**Design Report – Response to Submissions  
Section 96(2) Modification Application SSD-6013**

DEVELOPMENT APPLICATION  
 NORTH WEST PLOT  
 GROUND FLOOR PLAN

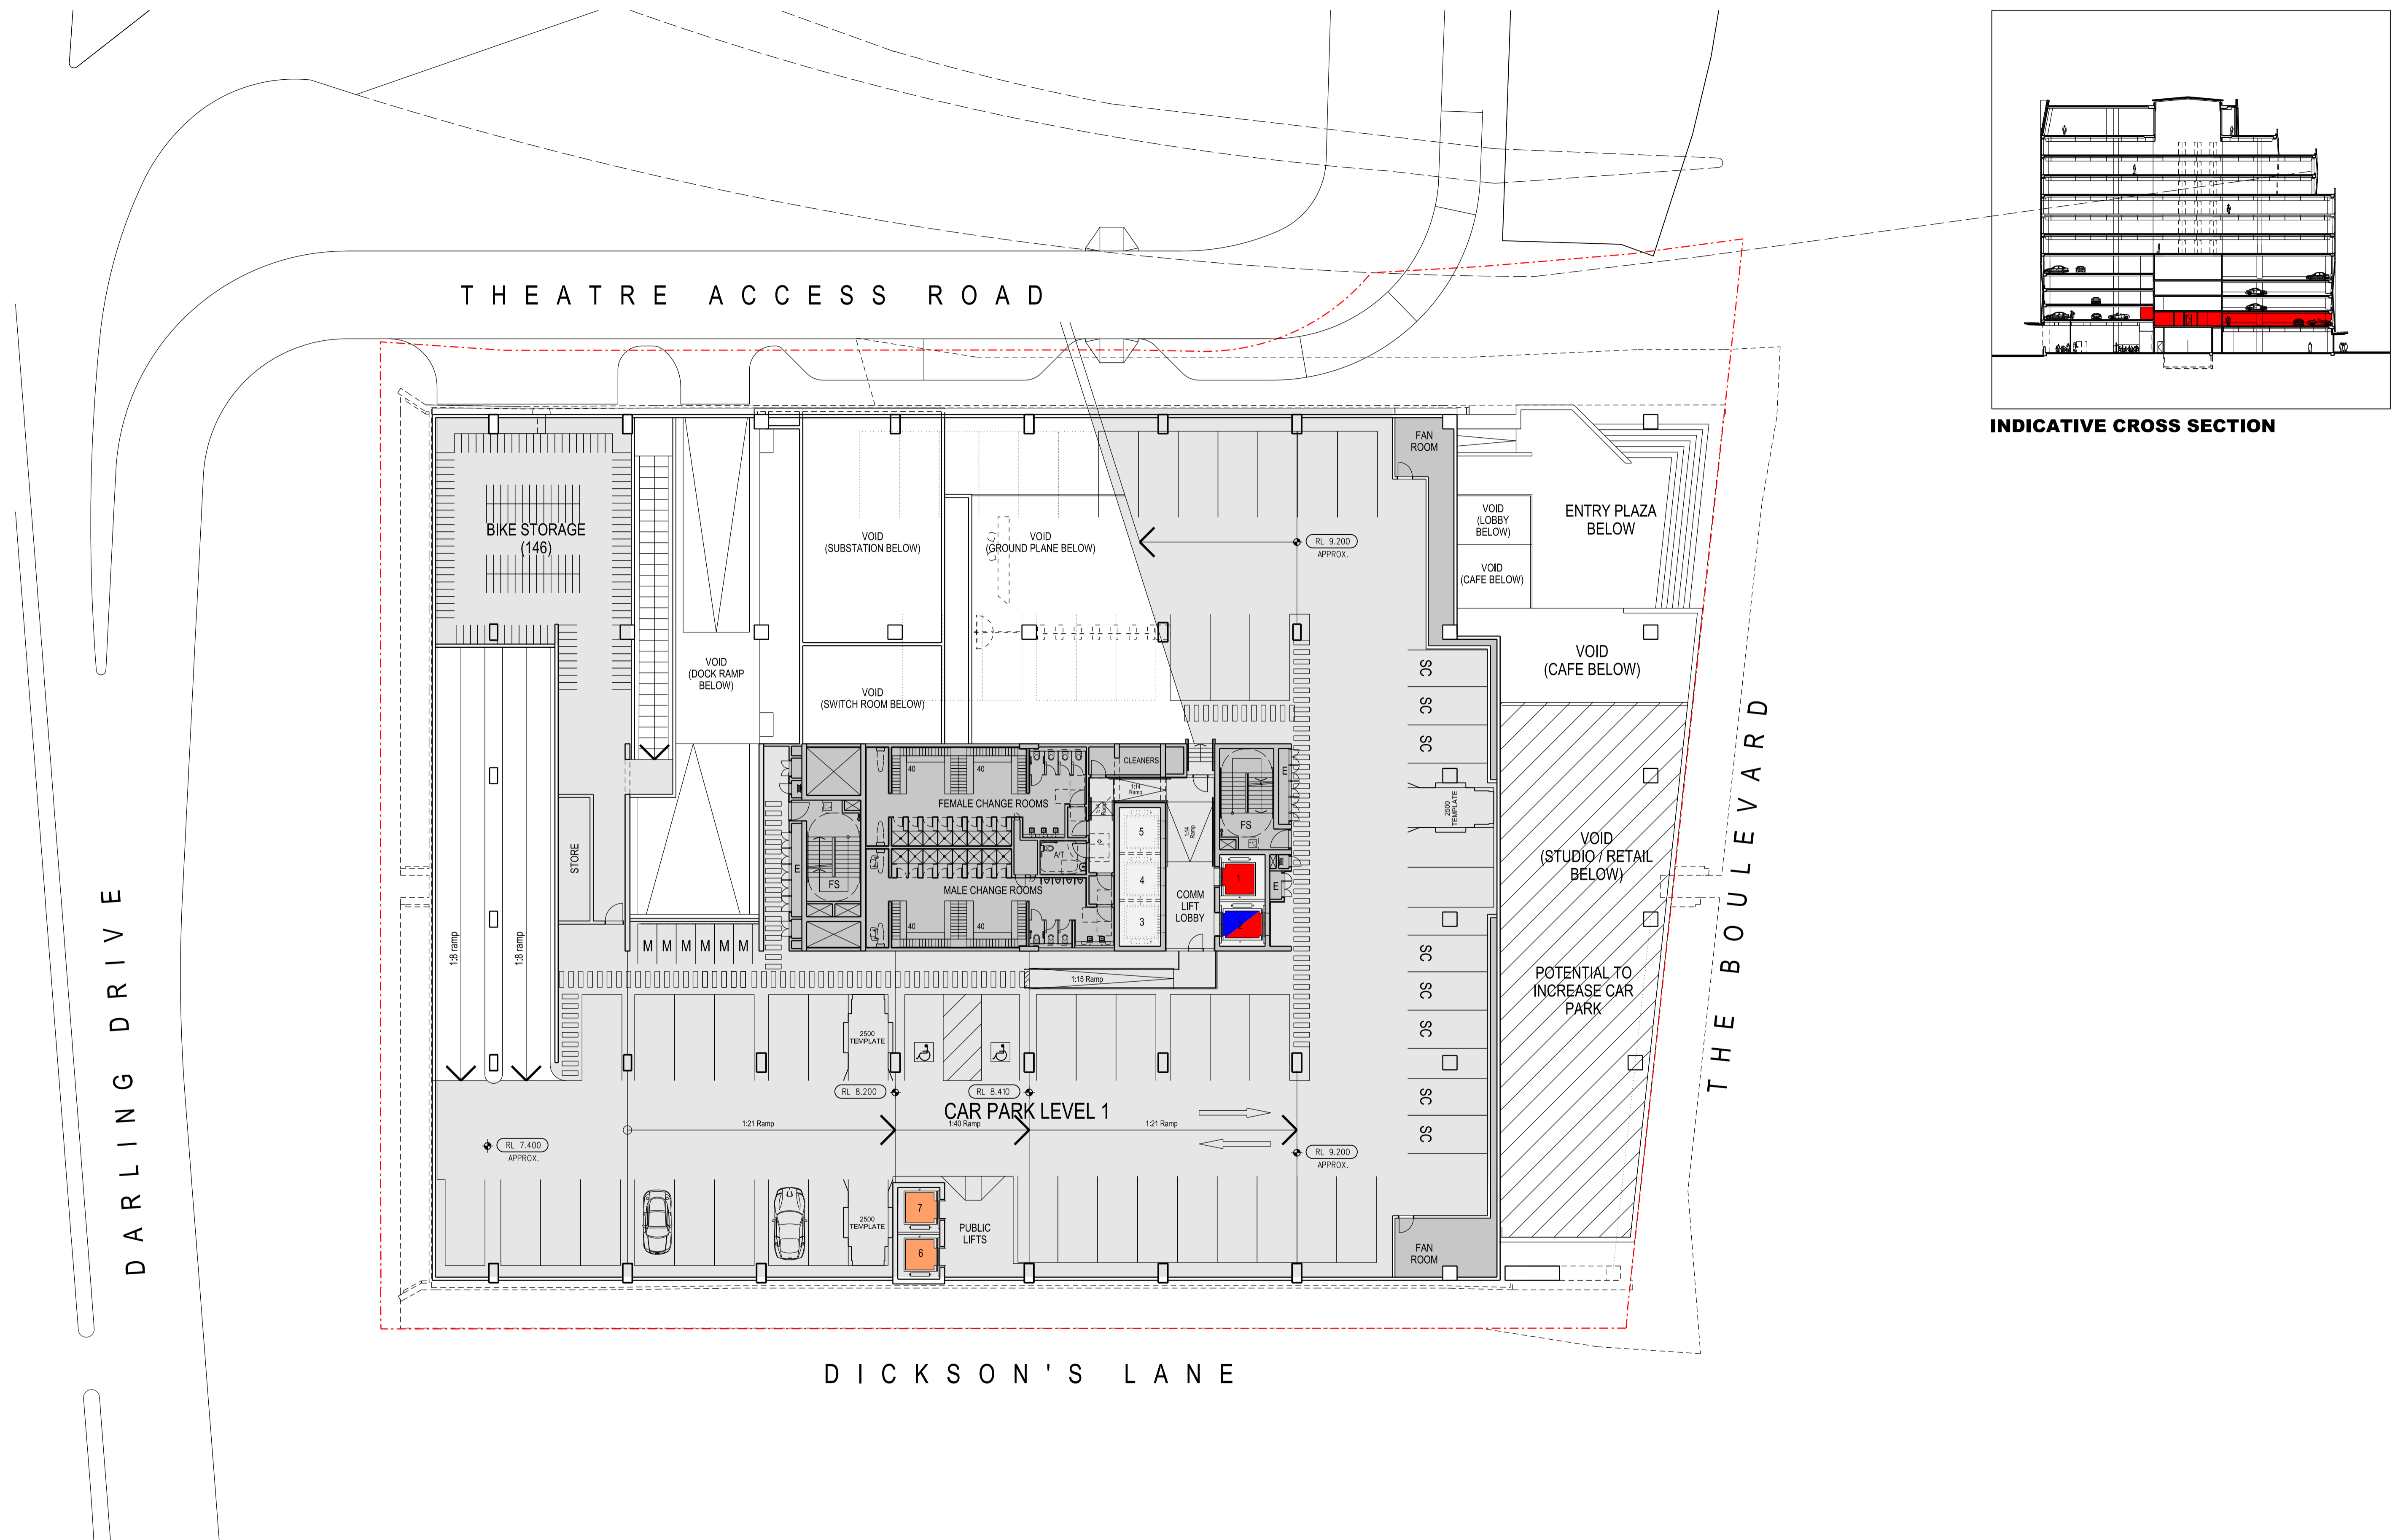
The ground floor layout has been amended to increase activation of the northern frontage by realigning the north east corner of the building. The north east corner has been extended north, towards Theatre Access Road, to highlight and further activate this important corner.

The transition from The Boulevard up into the north east corner's active uses has also been amended. The interface is now supported by a gentle geometry, with stairs that wrap around the corner. This will facilitate pedestrian flow from Theatre Access Road and the north beyond, while maintaining good sight lines at ground level.

As part of response to submission, the proposal has consolidated some plant space at ground level, and to accommodate 359sqm GFA of additional active uses space along Dickson's Lane, further strengthening the ground plane interface. Some back of house areas at ground level have been reorganised to allow for this.
